Department of Planning and Environment

**Re: Alterations and additions to St Philip's Christian College Cessnock campus (SSD-10360337)(Cessnock City) EIS**

# Detailed advice to DPE Planning & Assessment regarding the St Philip's Christian College Campus (SSD 10360337) Environmental Assessment

Drawing:
C-8

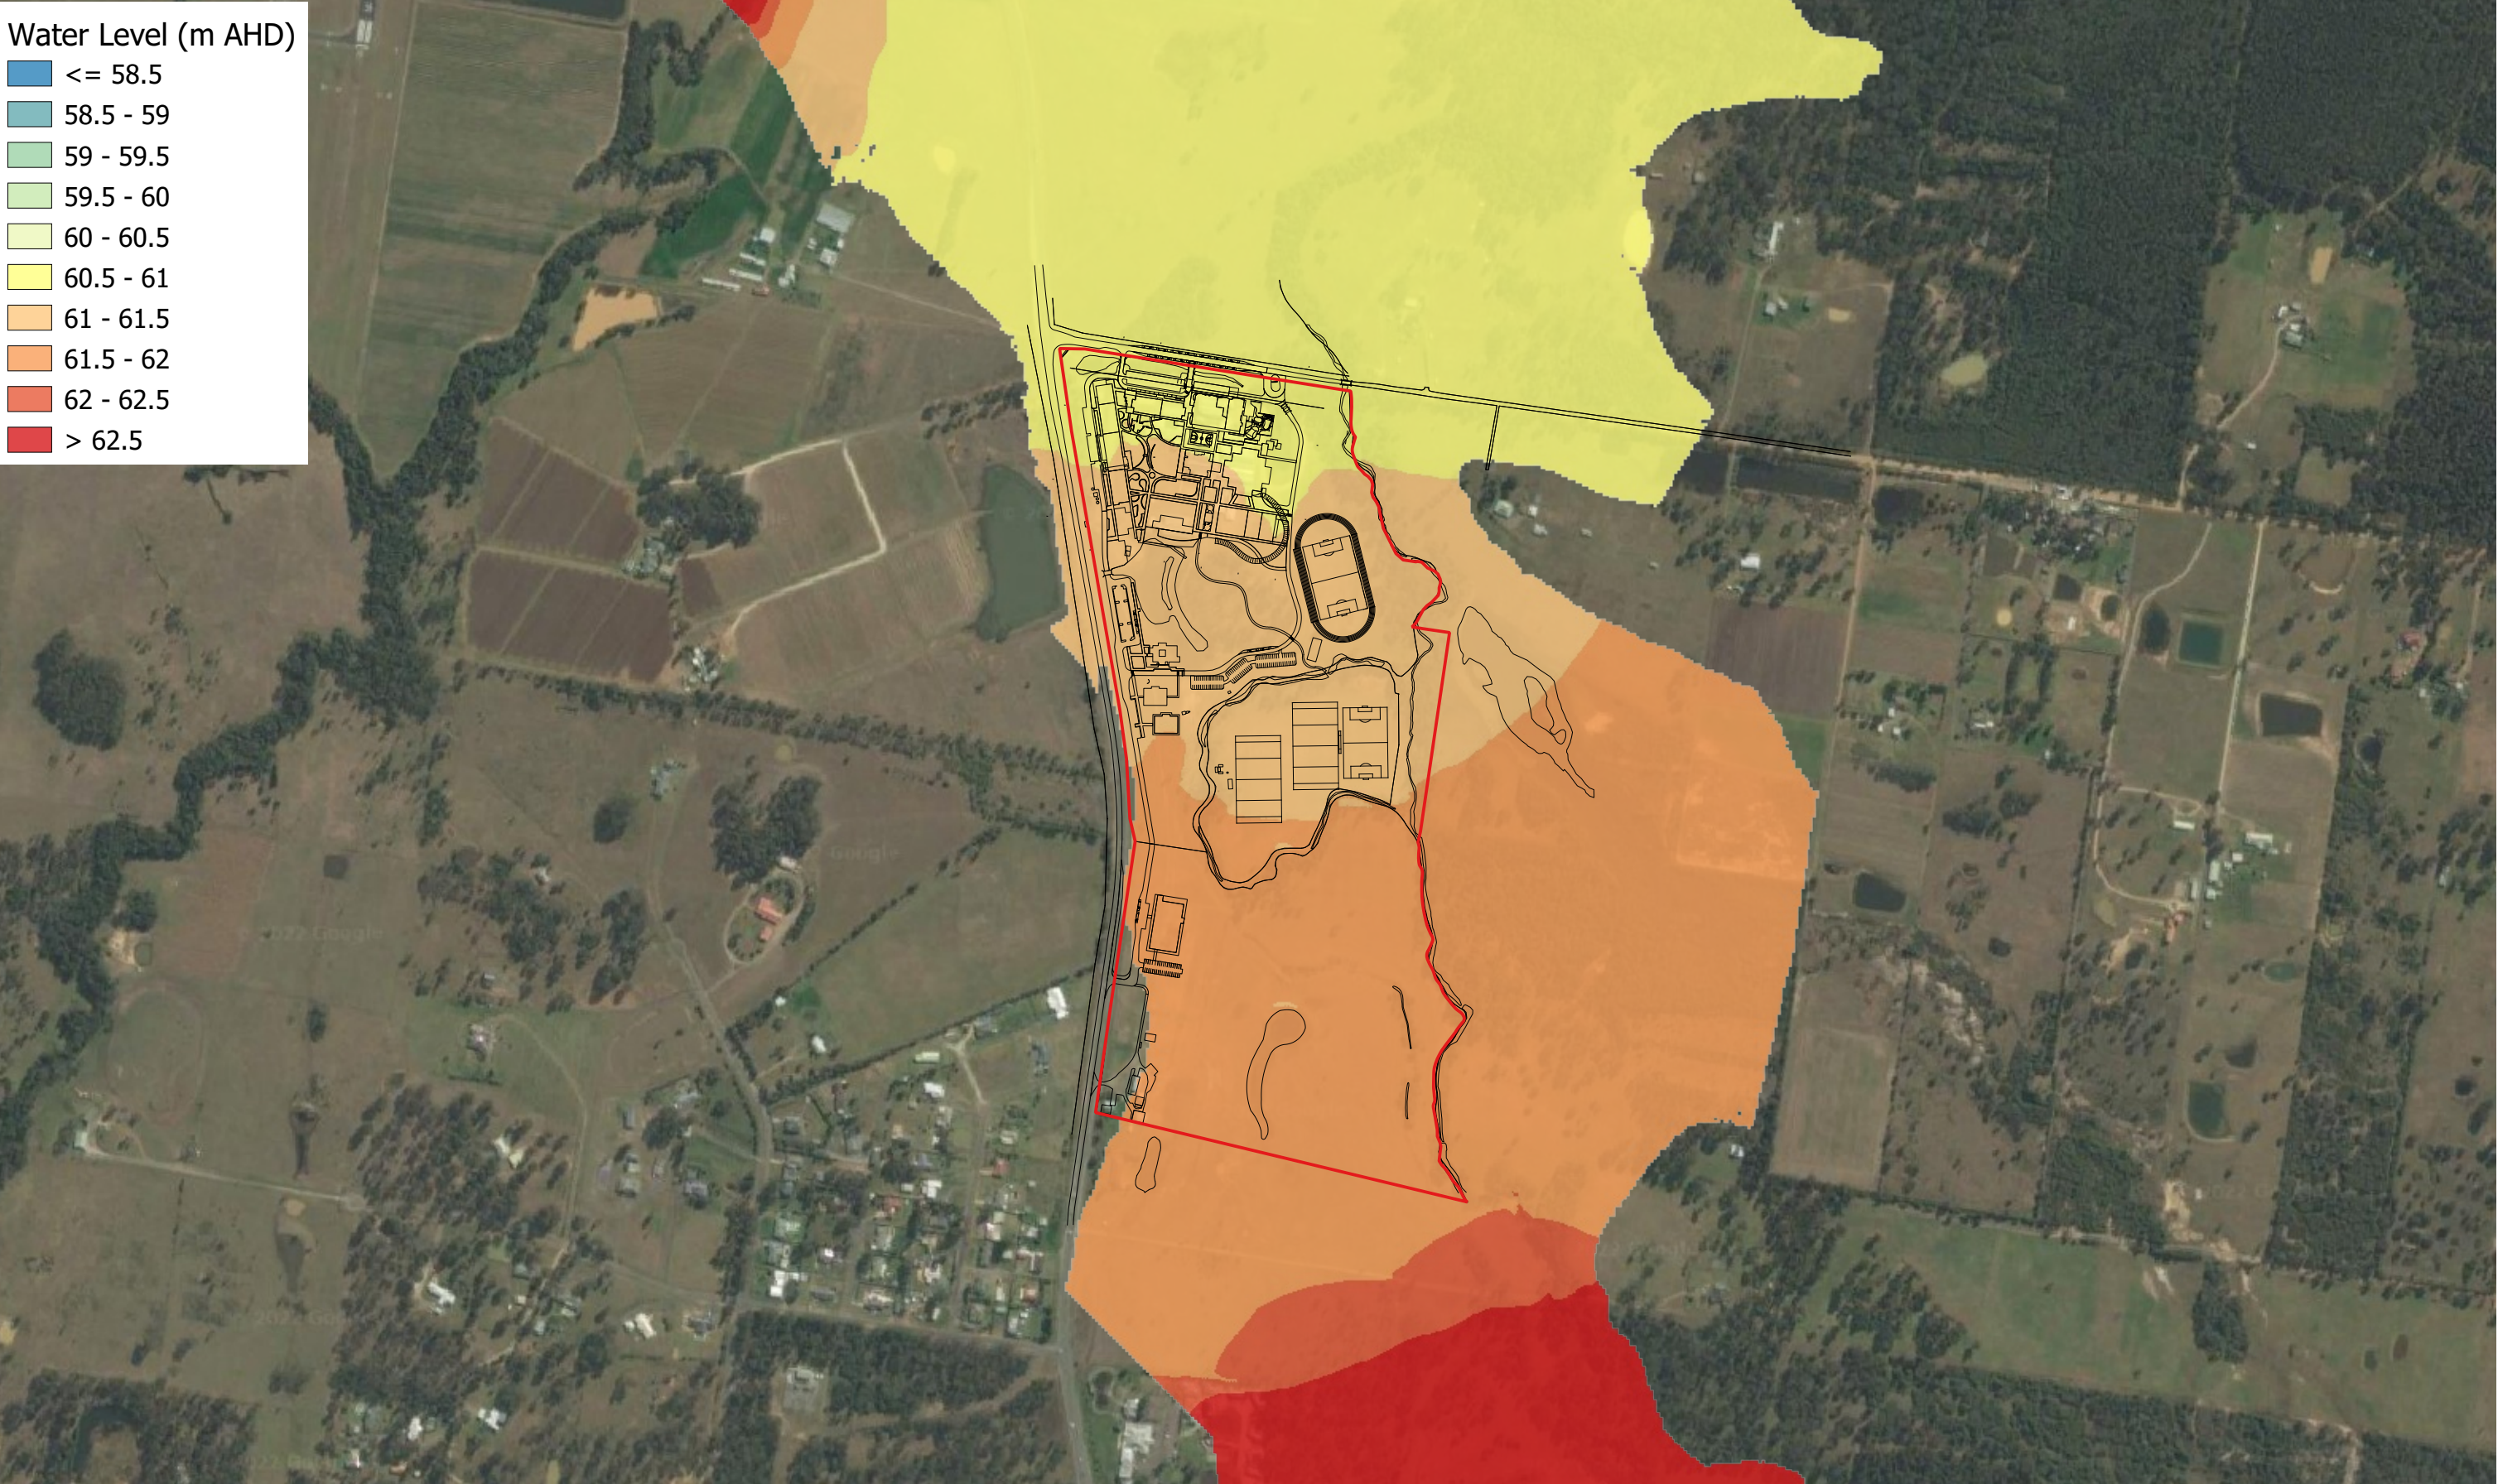
The EIS has considered off-site flood impacts, but not potential geomorphic impacts arising from increased flood flow velocities. With 24,500 cubic metres of fill into the site, the floodplain for Black Creek will in effect be constricted by the new building footprints. The effects of such constrained flow during peak flood events has not been explored. The proponent should, with reference to the NSW River Styles Database, consider the likely geomorphic impacts of the project on downstream environments, most notably the broad bridge crossing Black Creek on Lomas Lane. Mitigation options to prevent incision, erosion and infrastructure damage may need to be explored.
